Planning Application: 6/2023/2321/FULL

Main Details	Constraints	Location	Decision	Documents	Consultees	Neighbours	History	NMAs
Application Type	FULL PERMISSION			Status	Under Consultation			
Case Officer	Ms Elizabeth Mugova			Case Officer Email	e.mugova@welhat.gov.uk			
Location	Cuffley Gate Sopers Road Cuffley Potters Bar EN6 4RY			Proposal	Erection of a new steel structure canopy (sheltering) for ventilation and storing goods for the manufacturing process and extension to existing sheltering by the west block for ventilation and storing goods for the manufacturing process

As the immediate neighbour and owner of Sopers House I object to the development proposed.

PROPOSED ROOF PLANS

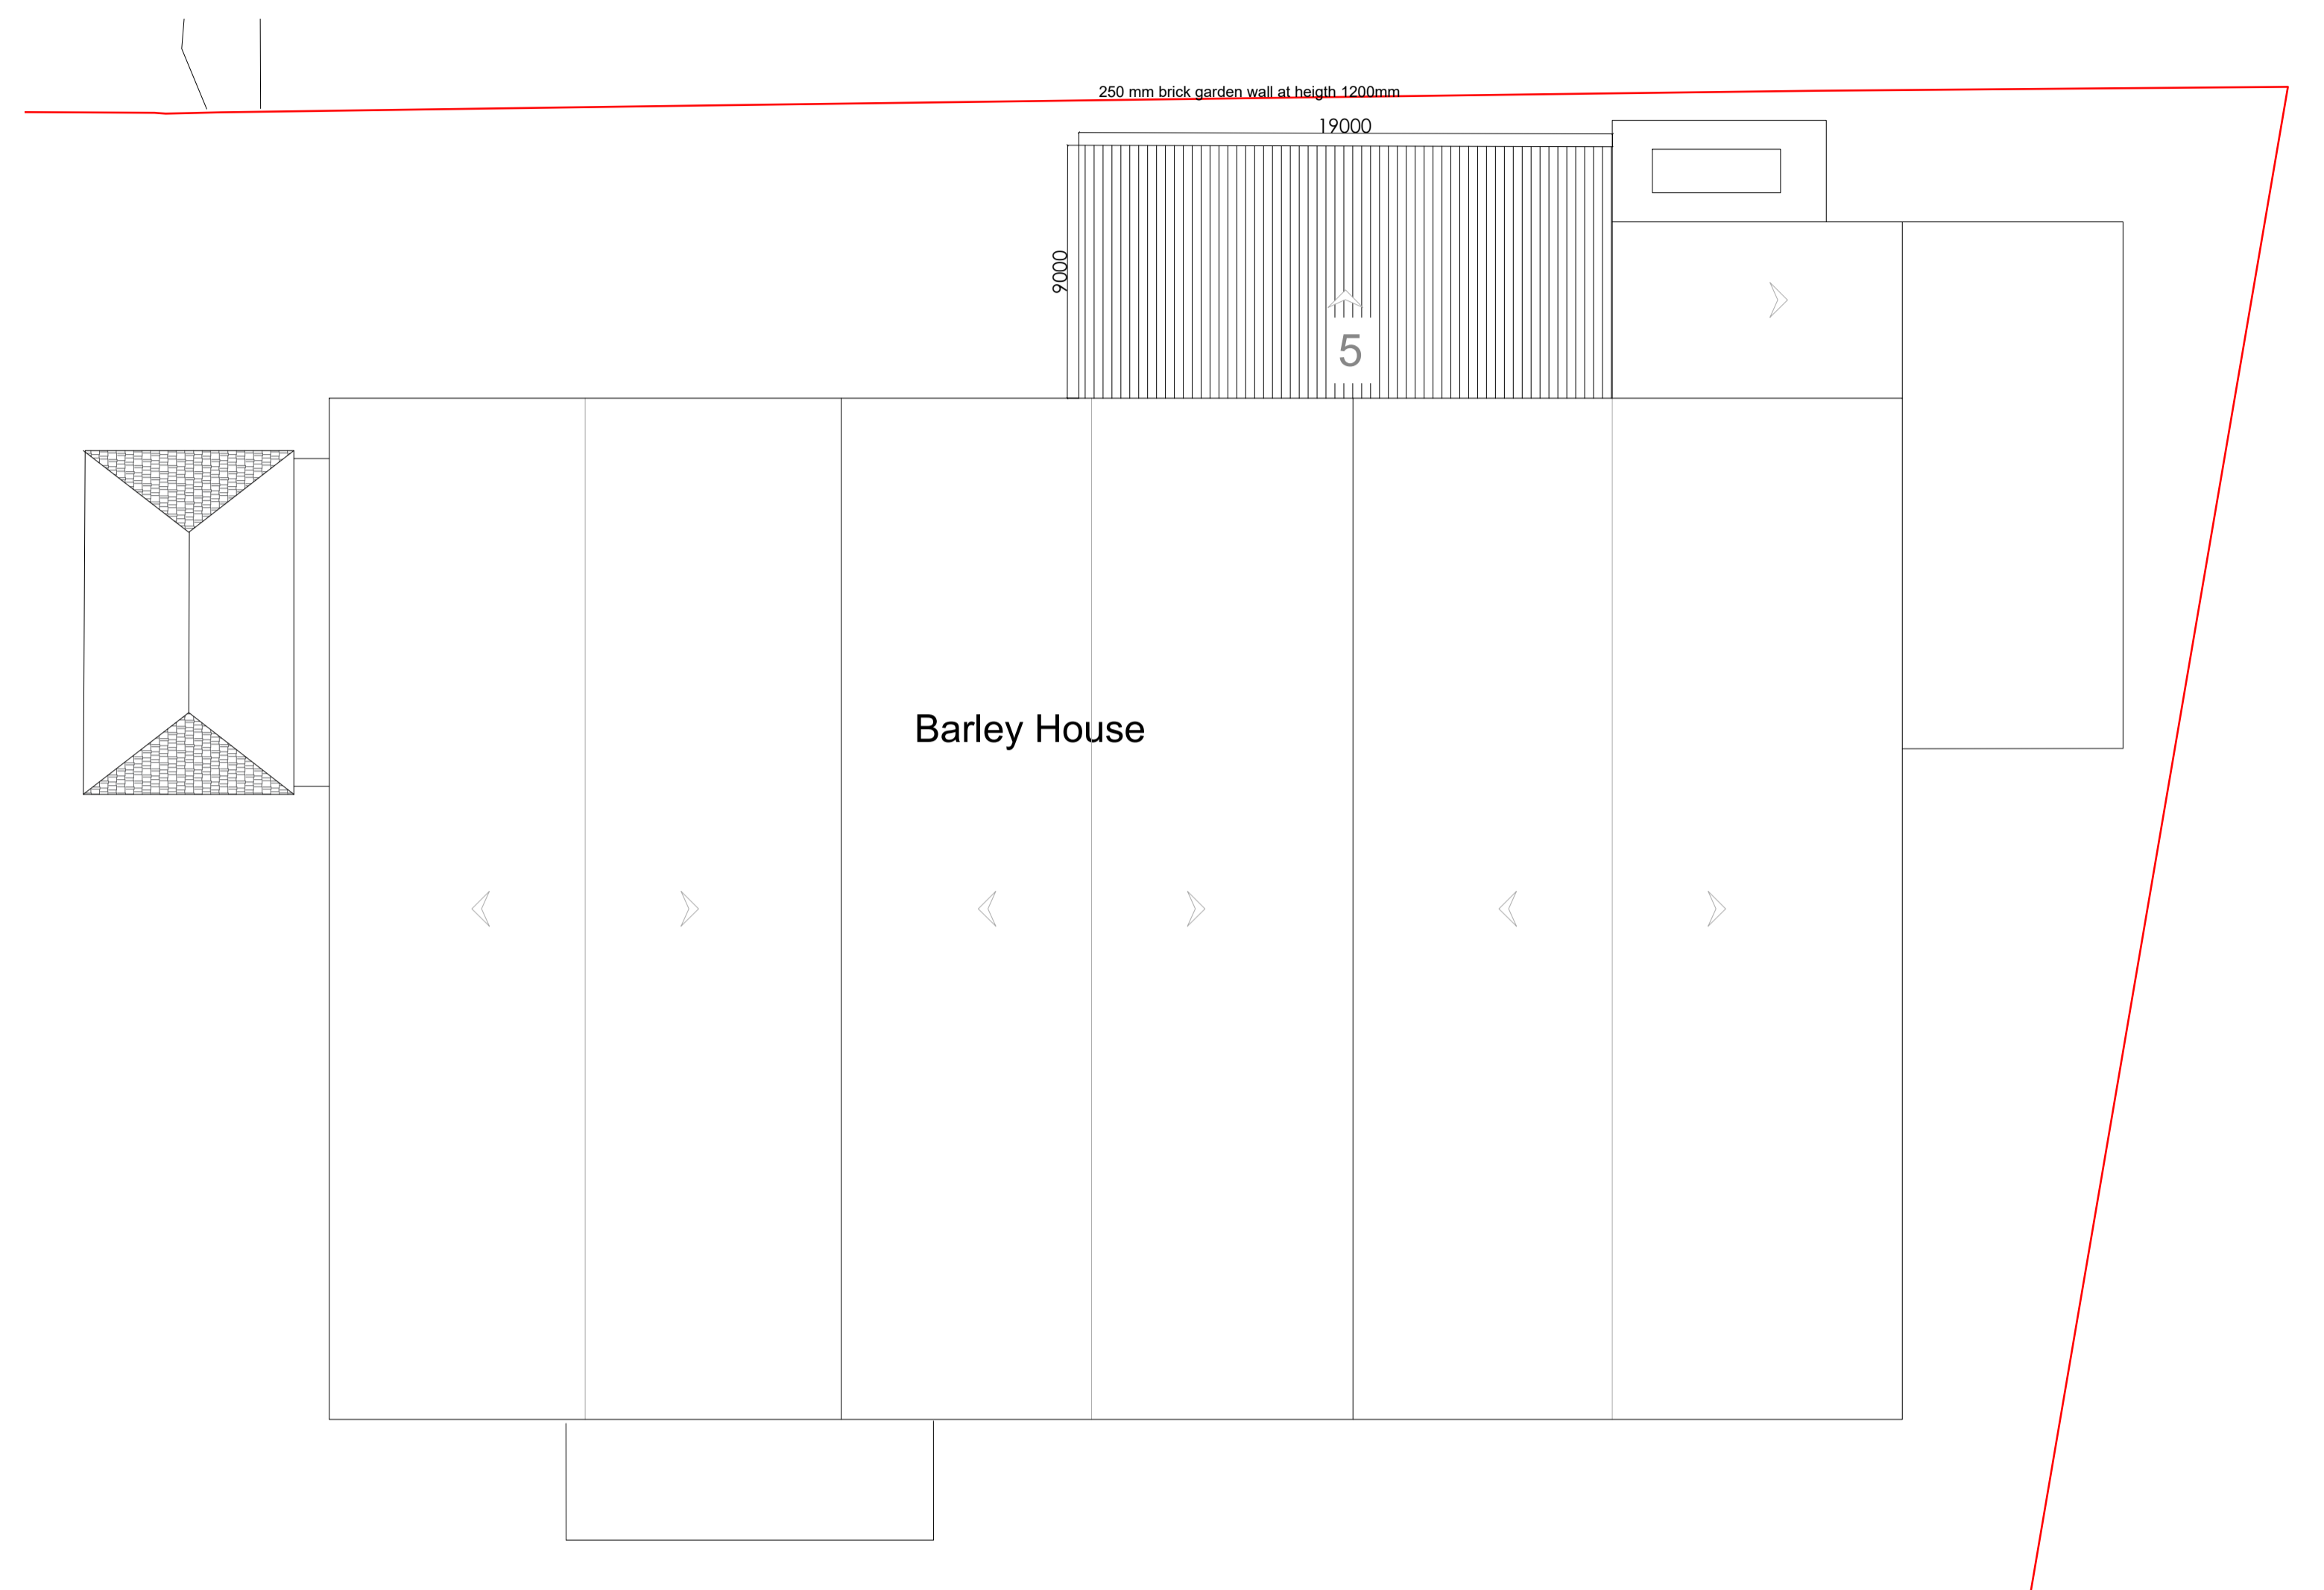
The proposal to extend the existing building further along the boundary would result in not only a significant loss of light to these business units but also a loss of outlook – the submitted plans do not give the full picture of how this will look. The extension would be a considerable height and built of temporary type materials with no regard to design and its adverse impact on the high quality development of Sopers House its neighbour a few feet away.

The design and use of materials is aesthetically poor and harmful to the quality of the area and outlook of occupiers of business rooms in Sopers House whose sole outlook is towards the proposed extension and within a few metres – the proposed extension extends right to the common boundary.

The scale, height, size and bulk of the proposed extension would result in a loss of light to the adjacent business units only a few metres away.

The proposed extension would increase the built area of the site and remove areas for parking and manoeuvring of vehicles on a site and within an area suffering from parking stress and insufficient on site availability to accommodate larger vehicles and car parking.

TITLE:
PROPOSED ELEVATIONS

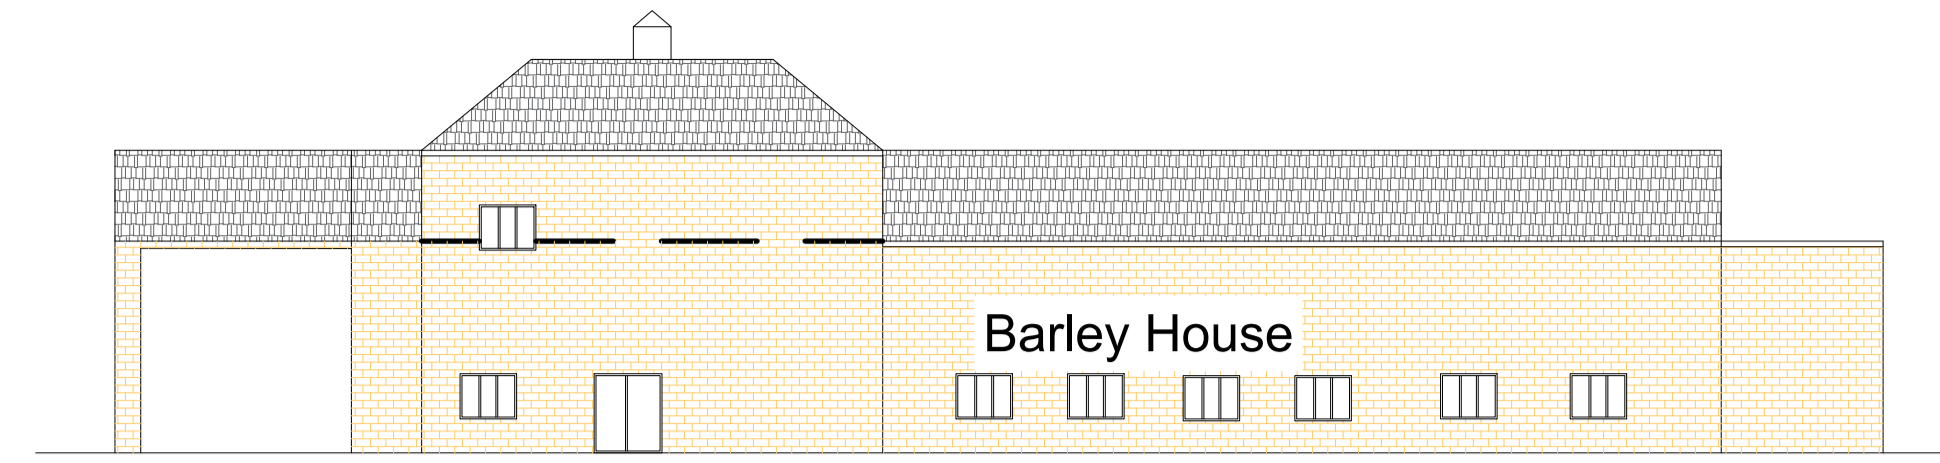
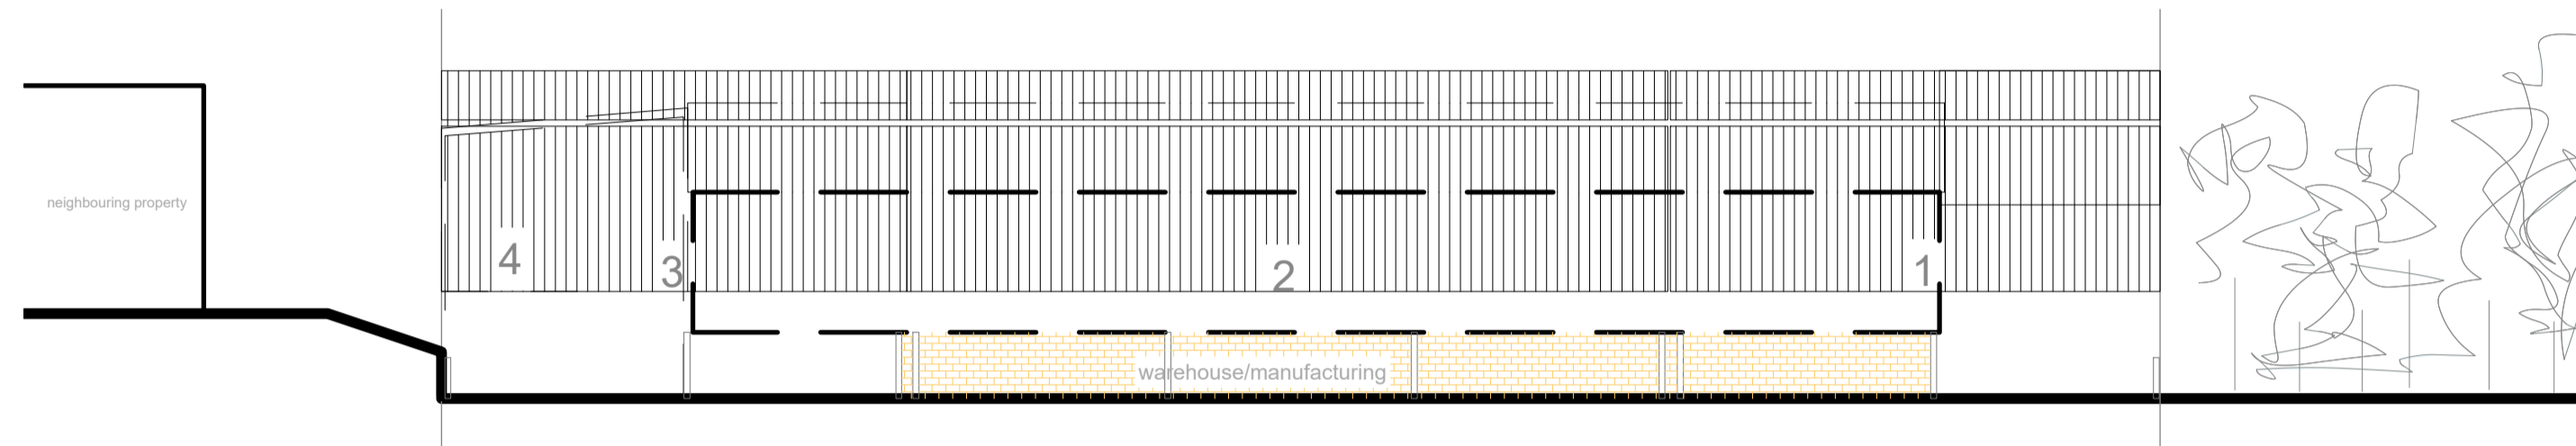
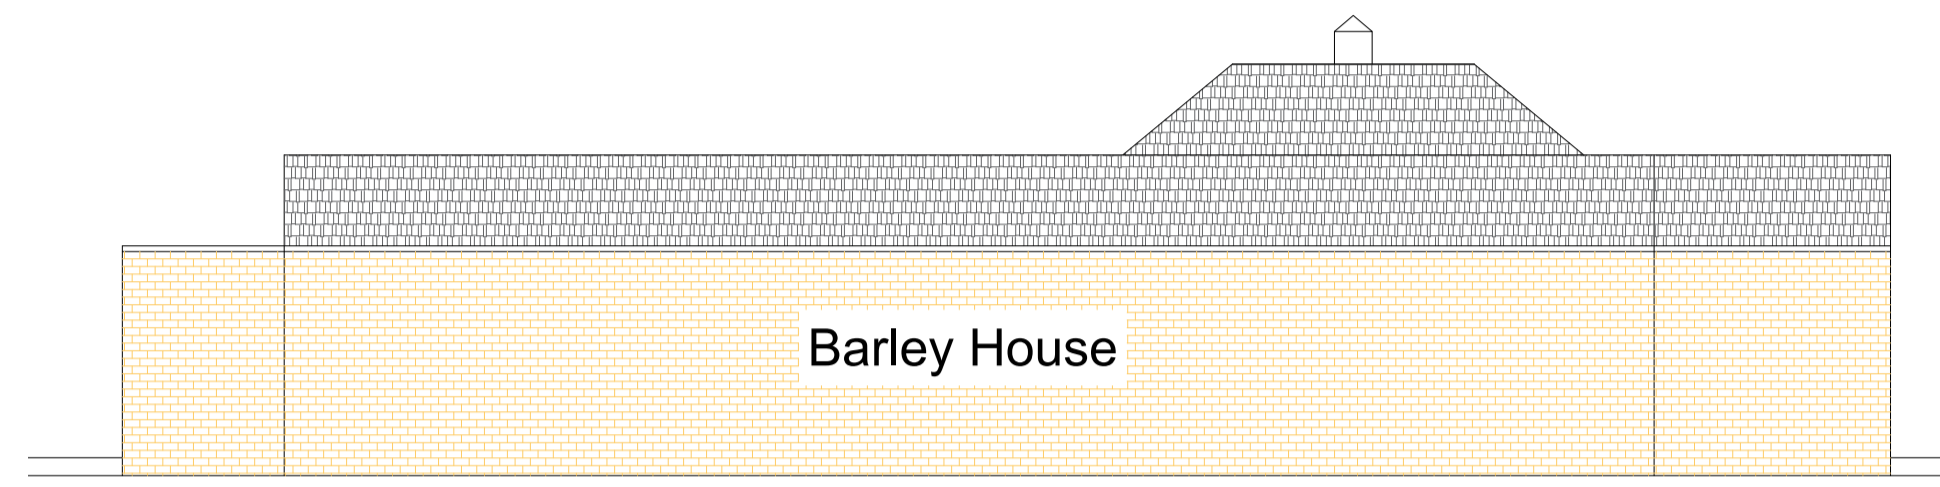
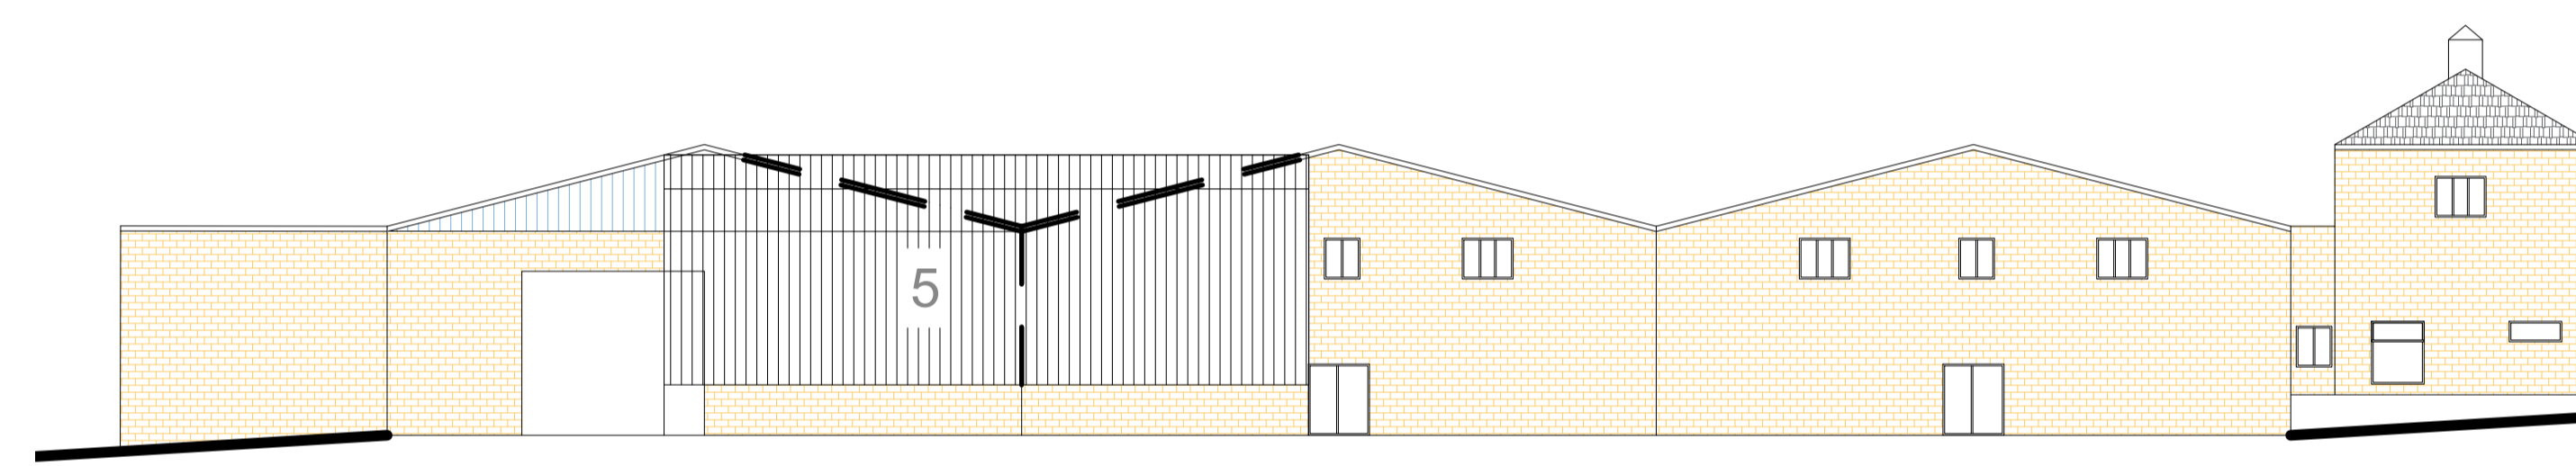
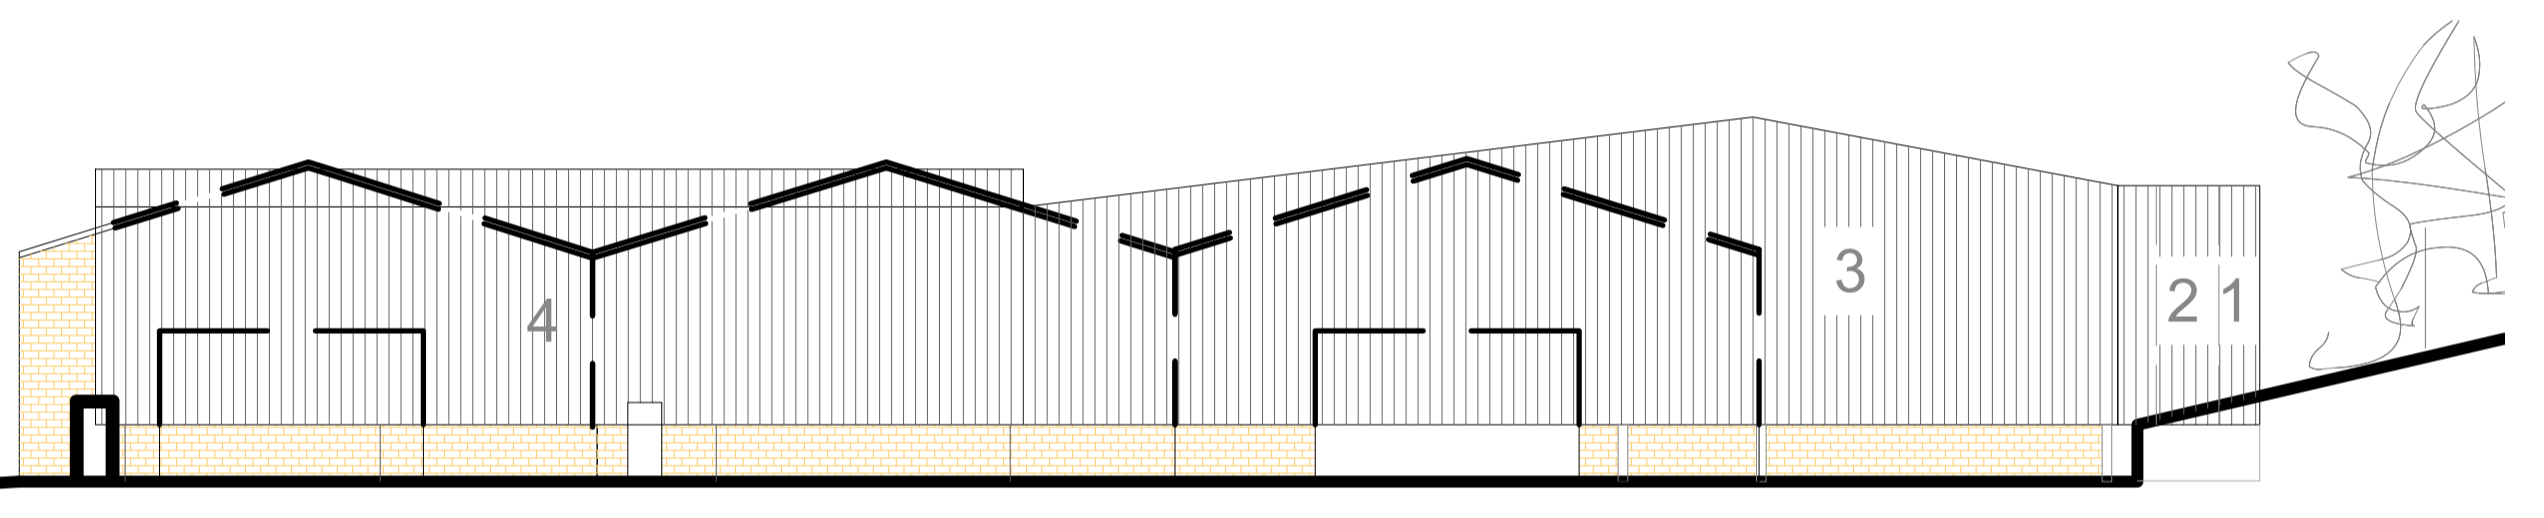
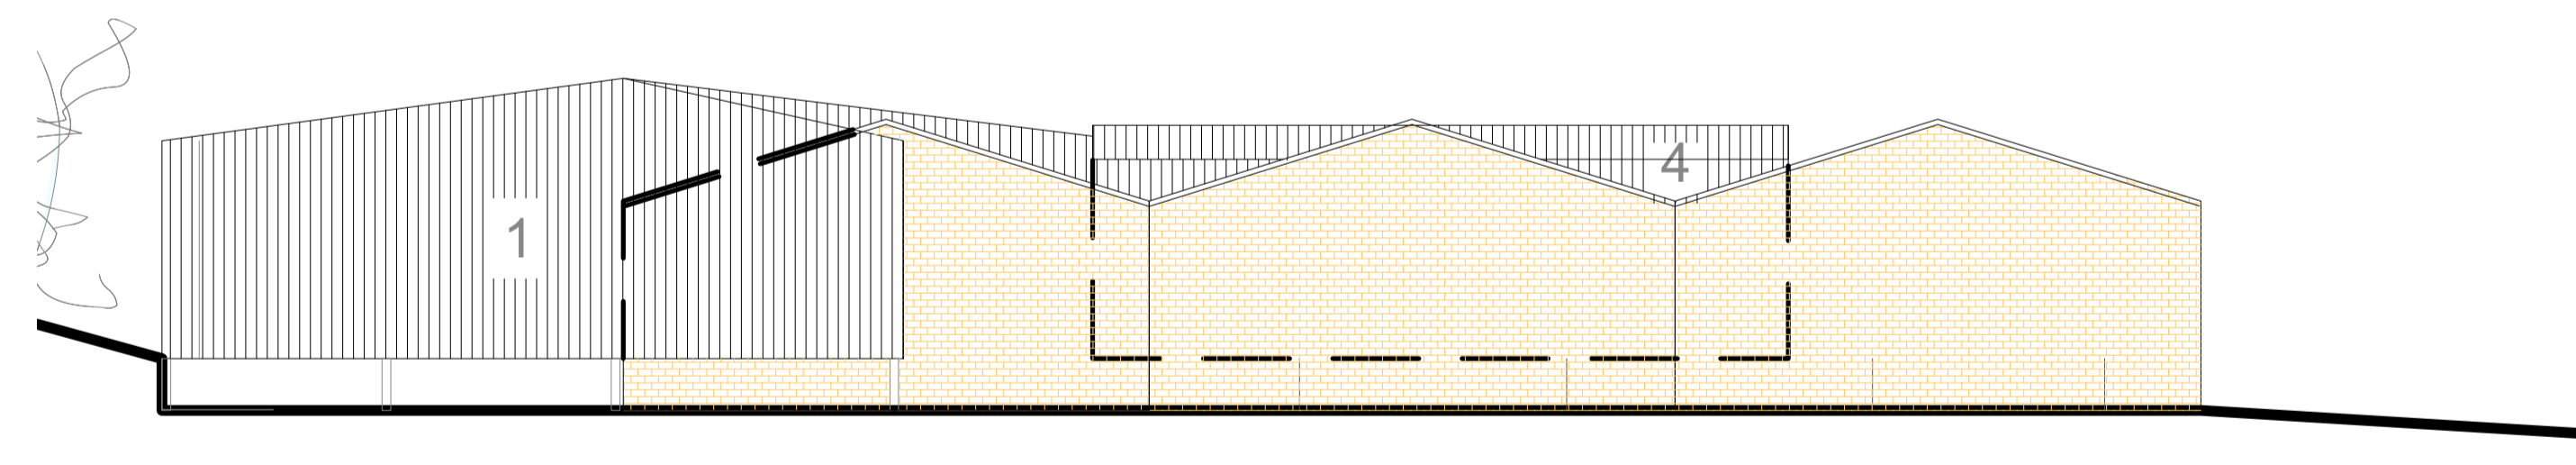
The bulk, height and scale would tower over the boundary and adversely impact the sole windows and outlook of new business units in the end elevation of Sopers House who would be facing ugly to look at steel sheeting.

The design quality is poor.
